# Permit Reviews

**Permit Number: SFD2311-0013**

Description: **63x40 sfd 4 beds 3 baths**

Site Address: **2026 SHADY GROVE RD**

Mayview Plan - Elev. C

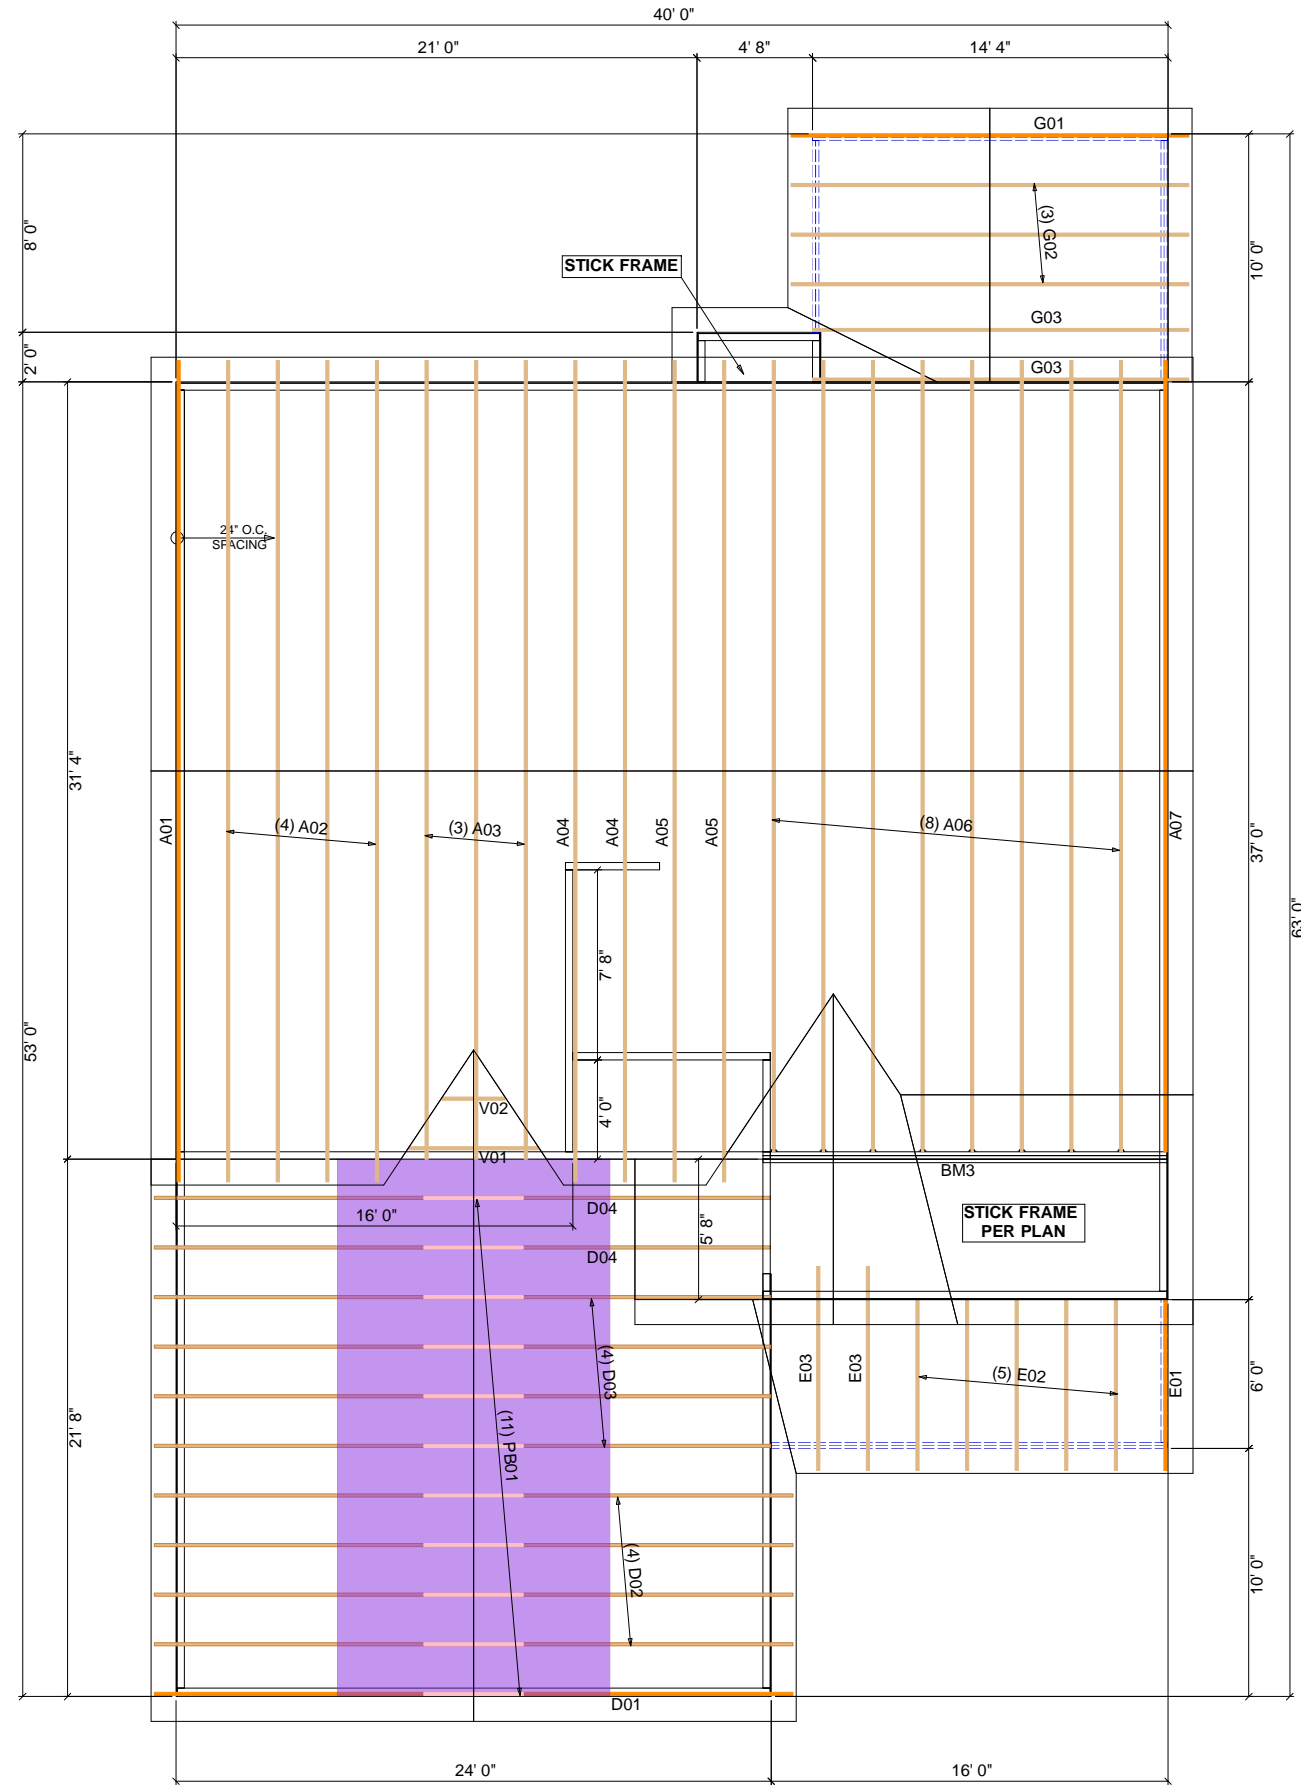
SENT DATE	RETURNED DATE	DUE DATE	TYPE	CONTACT	STATUS	REMARKS
Review Group: 2ND PLAN REVIEW						
1/12/2024	1/19/2024	1/29/2024	ENVIRONMENTAL	MARK OSBORNE	APPROVED	
Notes: permit to be drawn						
Review Group: AUTO						
11/2/2023	12/18/2023		SFD INTAKE	CP Bucket	APPROVED	
Notes:						
11/2/2023	11/16/2023	11/17/2023	ENVIRONMENTAL	MARK OSBORNE	UNDER REVIEW	
Notes: Client will call when front property irons are located and exposed						
12/18/2023	12/21/2023	12/21/2023	RESIDENTIAL BUILDING	Brad Sutton	DISAPPROVED	in attach
Notes: Need all engineered product layouts (floor and roof trusses, i joists, etc) as well as LVL beam calculation sheets						
1/24/2024	1/29/2024	1/29/2024	RESIDENTIAL BUILDING	Brad Sutton	DISAPPROVED	in attach
Notes: Need the framing layouts for floor and roof. Only the cutsheets for trusses were submitted. Need all LVL calculation sheets as previously requested						
1/29/2024			RESIDENTIAL BUILDING	Building Bucket
